Recommendation Report

Application No.

BE/148/11

Loft conversion
66 Greencourt Drive Bognor Regis

Proposed Side Elevation

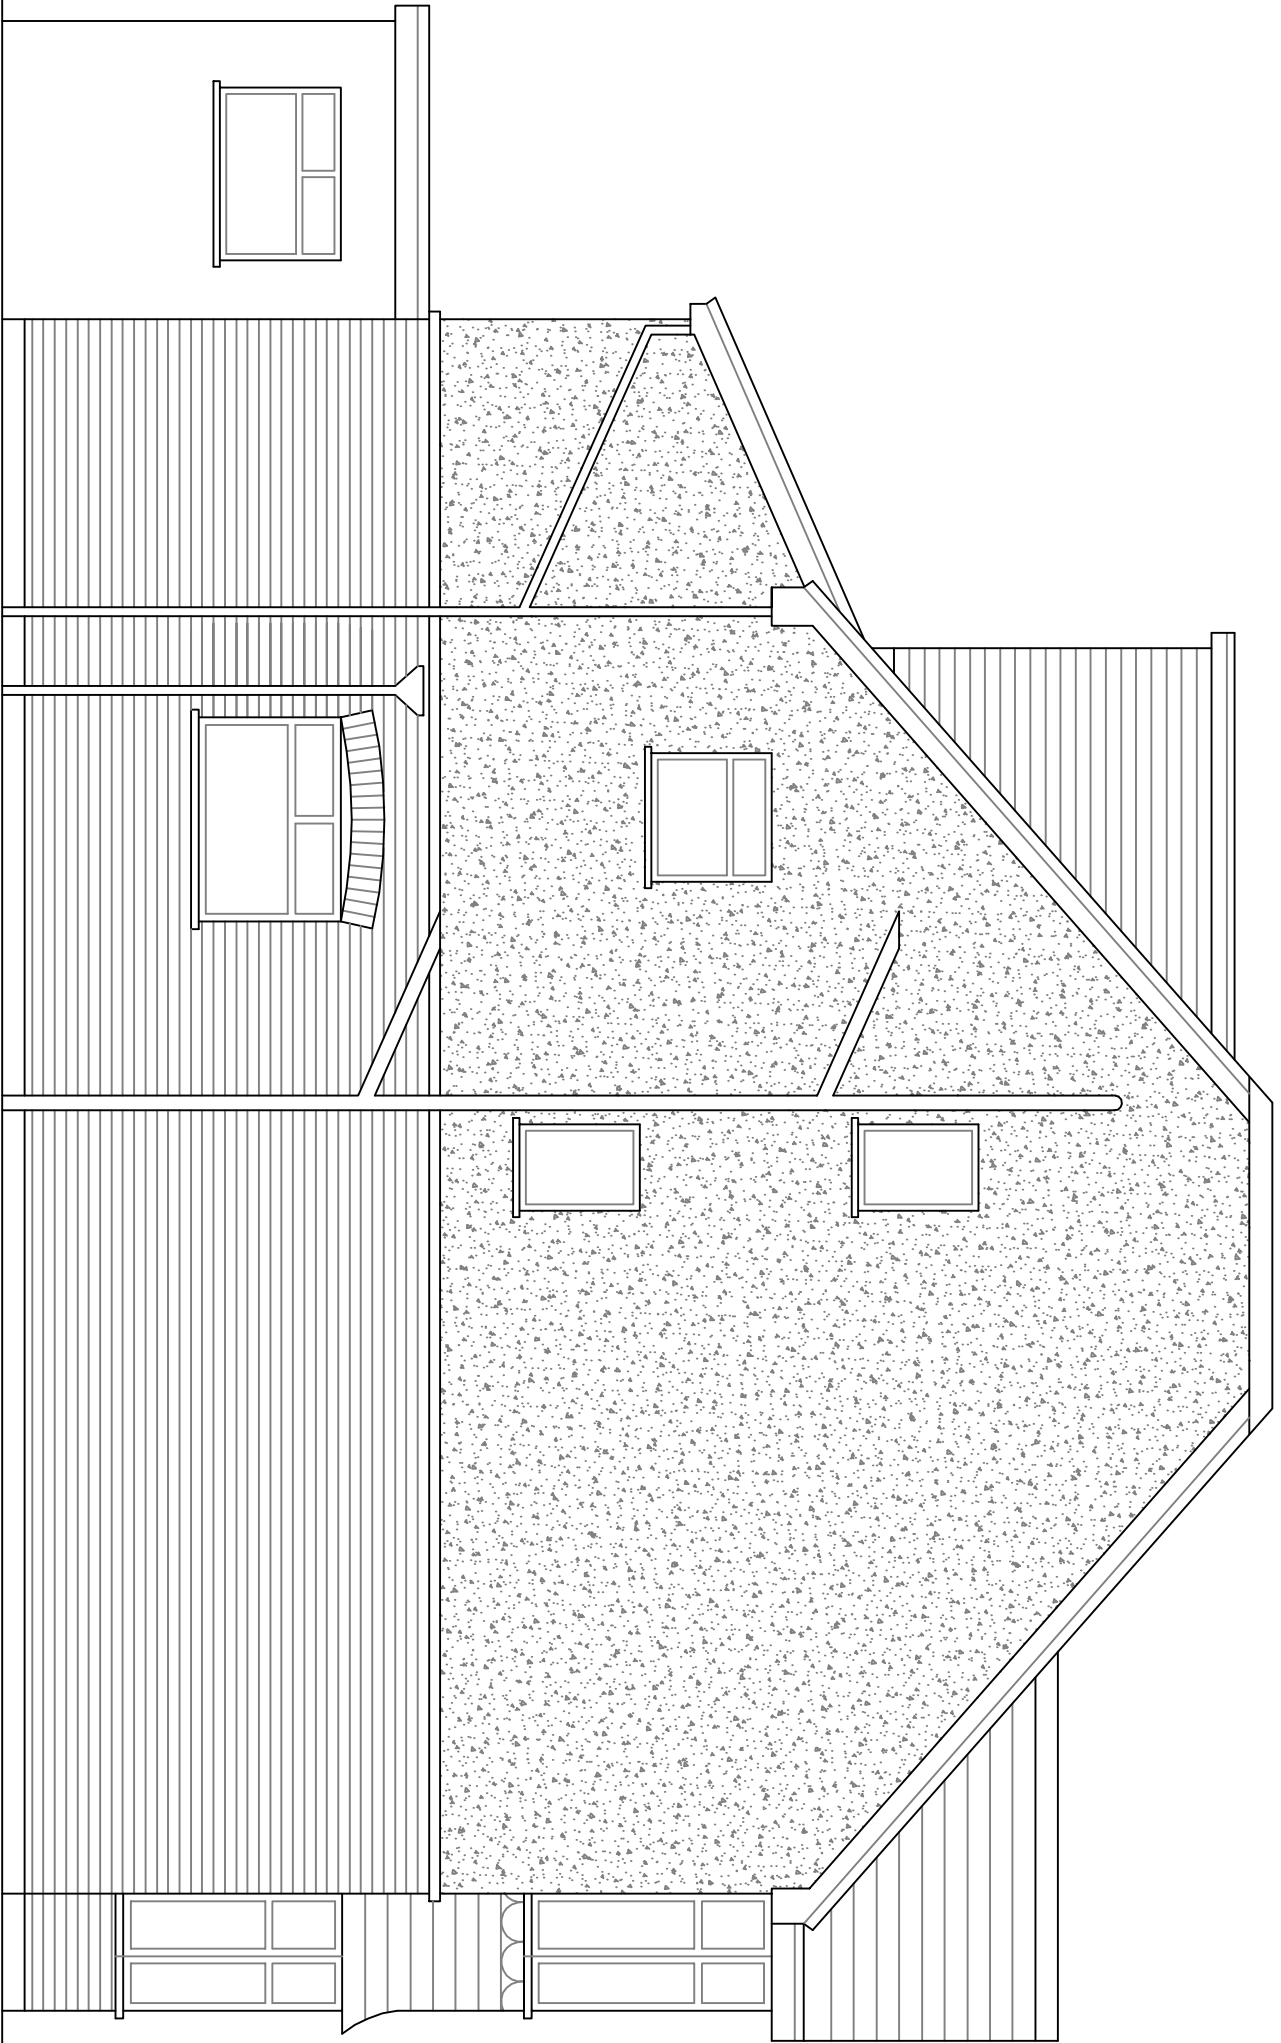
Please provide 1 electronic or 3 paper copies of a revised proposed side elevation as it does not coincide with the floor plan - there is a window missing, in accordance with the guidance notes available on our website detailed below (click on National List).

Proposed Front Elevation

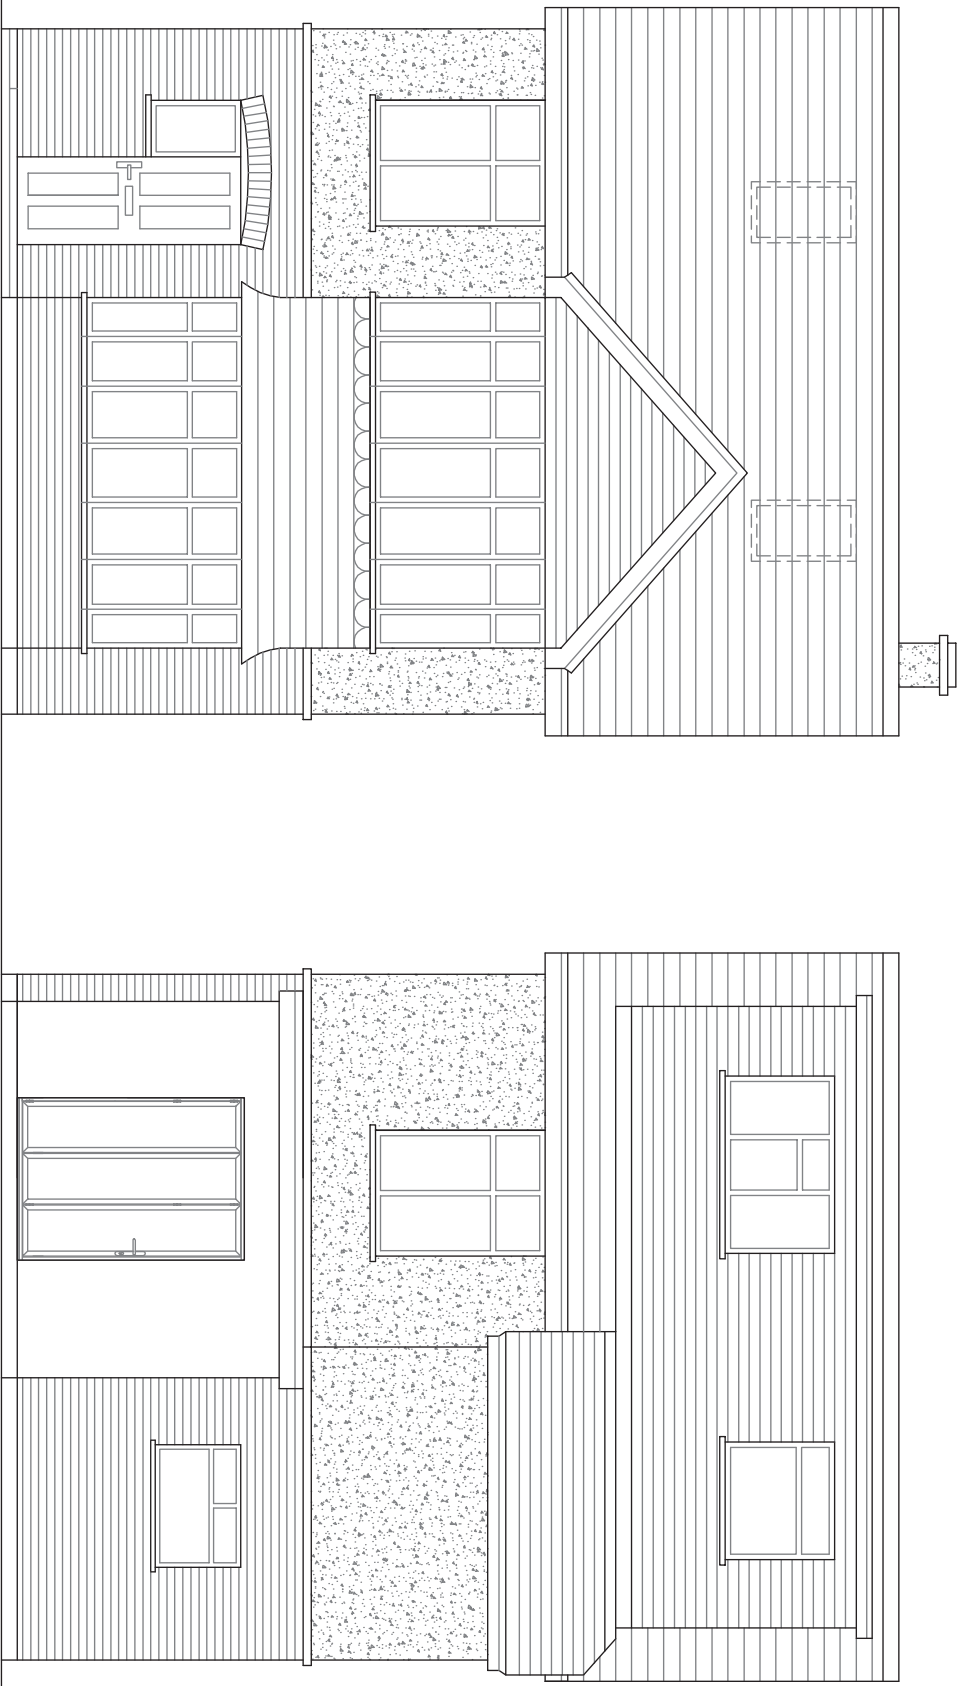
Please provide 1 electronic or 3 paper copies of a revised proposed roof plan at a scale of 1:50 as there are two rooflights detailed on this plan and not on the front elevation - please amend, in accordance with the guidance notes available on our website detailed below (click on National List).
